17 June 2022

**Subject:** EHG comments on Environment Impact Assessment for DHL Warehouse and Distribution Centre, 813-913 Wallgrove Road Horsley Park (SSD-36156297) and Gazcorp Industrial Estate (SSD-5248-MOD 2)

The Environment and Heritage Group (EHG) has reviewed the following reports for this State Significant Development (SSD):

CATCHMENT WAREHOUSE ROOF TO RAINWATER TANK	AREA: 2.995ha
CATCHMENT WAREHOUSE ROOF TO TRUNK DRAINAGE	AREA: 0.558ha
CATCHMENT IMPERVIOUS	AREA: 1.599ha
CATCHMENT PERVIOUS	AREA: 0.120ha
CATCHMENT BYPASS IMPERVIOUS	AREA: 0.115ha
CATCHMENT BYPASS PERVIOUS	AREA: 0.299ha

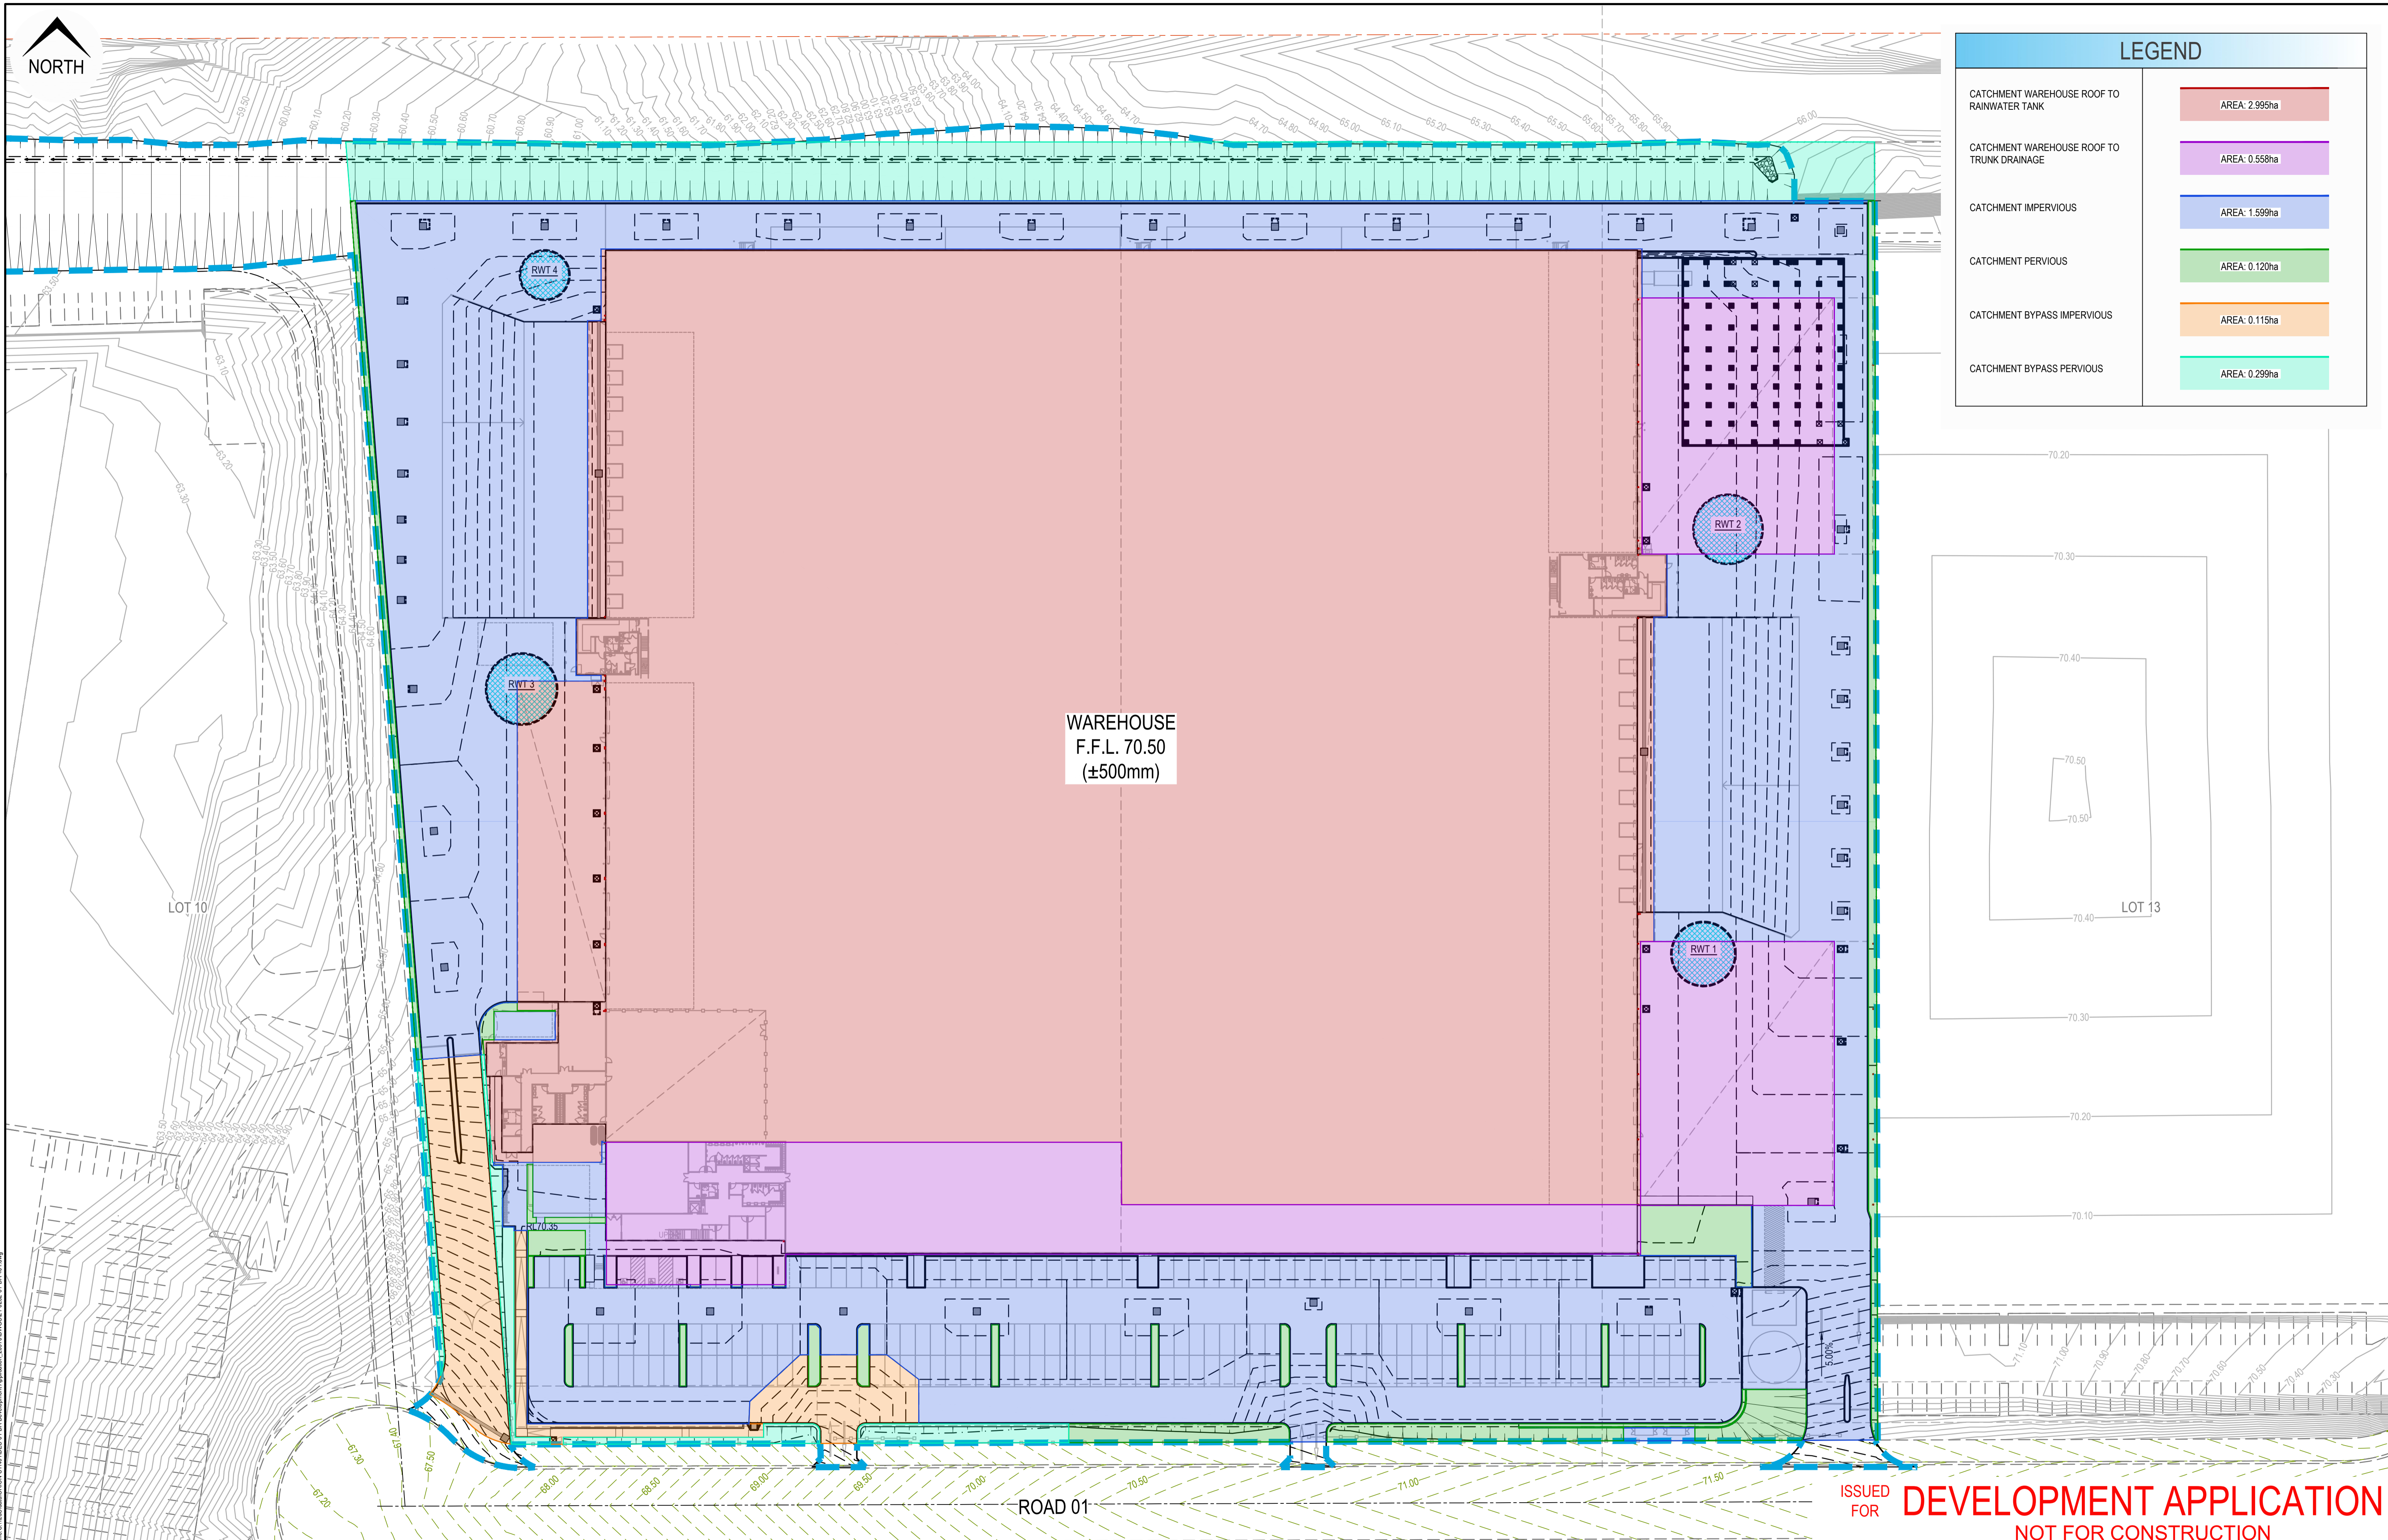
Appendix U of the EIS indicates that the impervious area at the development site would increase in Modification 2 from Modification 1 and this would be addressed by revising the stormwater management and limiting the runoff under the pre-development level with on-site detention storage.

Appendix J (Section 2 of Stormwater Management – Adopted Information) does not indicate whether the proposed changes in Modification 2 have been accounted for in the drainage network design including the on-site detention storage.

The proponent should update the stormwater management report by revising the previously designed drainage network and on-site detention storage to demonstrate that the runoff from the entire development site would be maintained at the pre-development level.
